DECISION DELEGATED TO HEAD OF PLANNING

Application No: H02-0670-26 **Applicant:** Mr & Mrs I Smeadley

Proposal: Alterations to the rear service wing allowing for rebuilding of chimneystack, structural repairs to gable end, replacement of rainwater goods, rebuilding of single storey structure, works to garden wall & internal works

Location: The Manor House 5 East Street Crowland

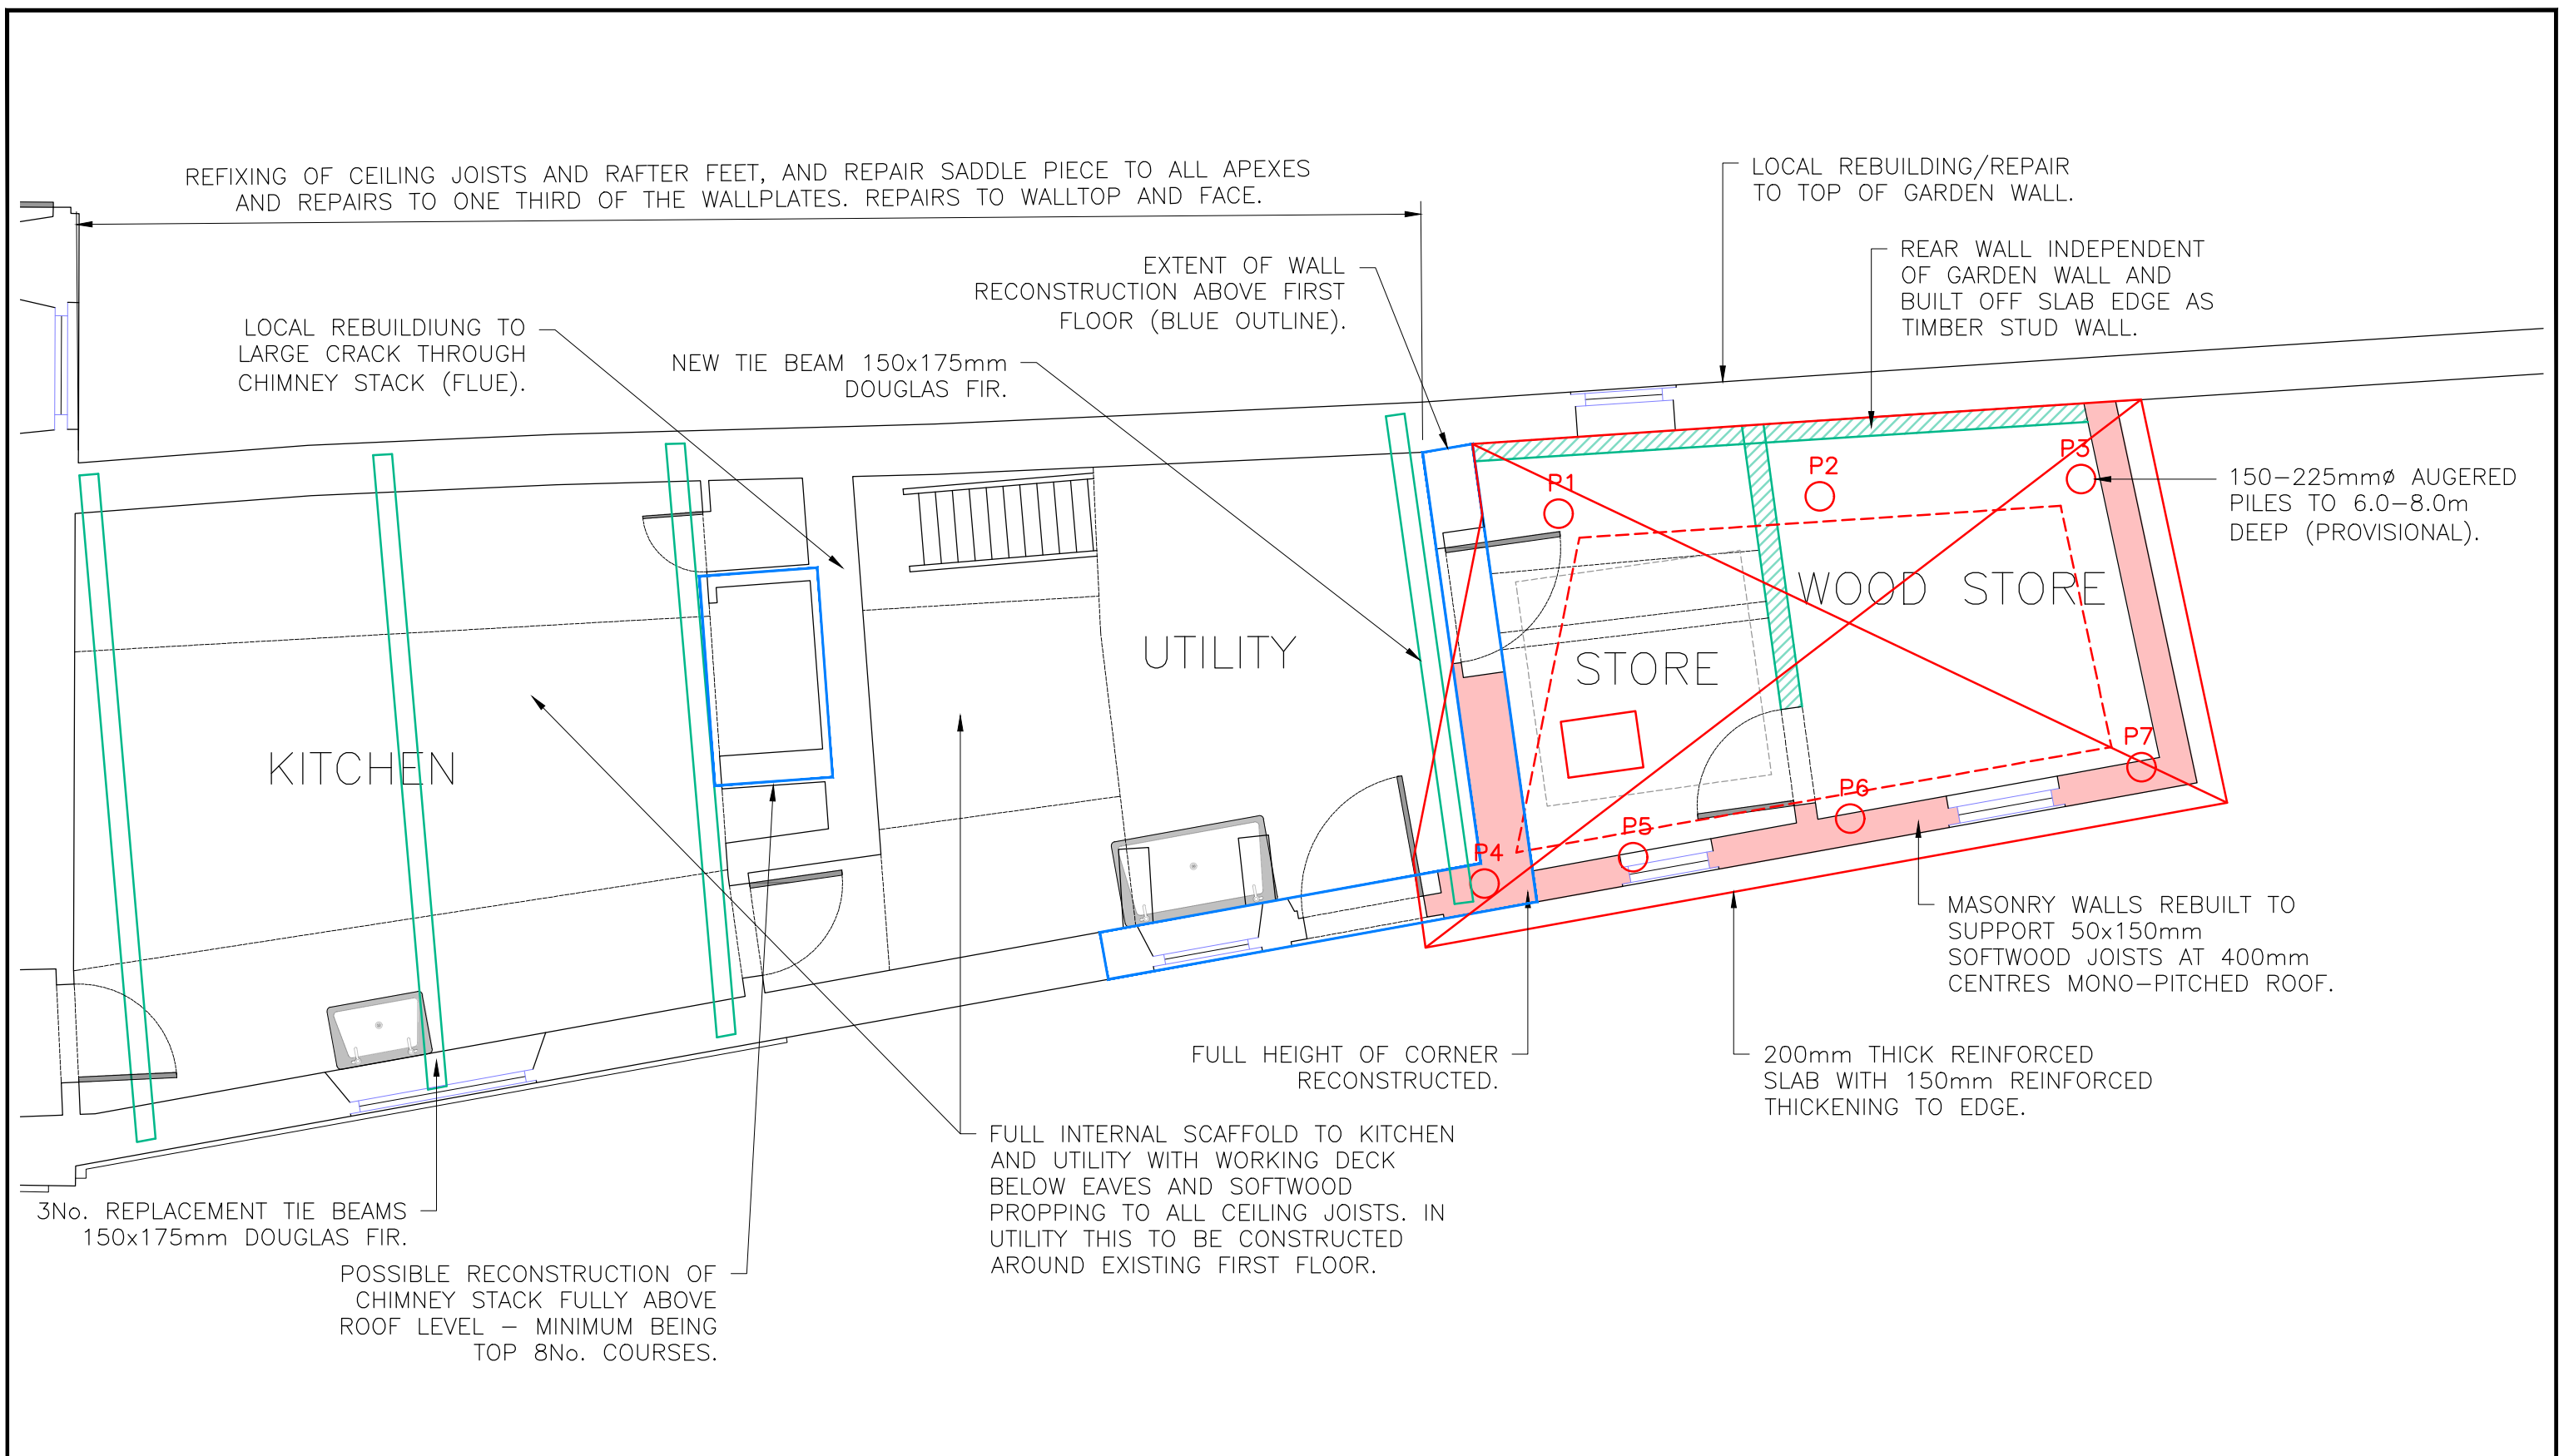
Similarly, structural repairs are proposed to the south gable (of phase E). The extent of works required are currently unknown, pending the demolition of the adjacent single storey outbuilding. If the extent of gable end brickwork proposed to be rebuilt deviates significantly from that indicated on structural drawing ref 22757/R/30 (Rev -) your Conservation Officer should be informed. We also recommend that proposed new brick is specified.

Moreover, in line with the recommendation of Historic England, an informative condition should be applied informing the applicant that should the works necessary to repair the south gable of phase E deviate from those included in drawing 22757/R/30 or the Statement of Justification for Structural Repairs, that the applicant or their representatives should contact the SHDC planning department's conservation specialist prior to those works taking place to discuss if those deviations require separate consents.
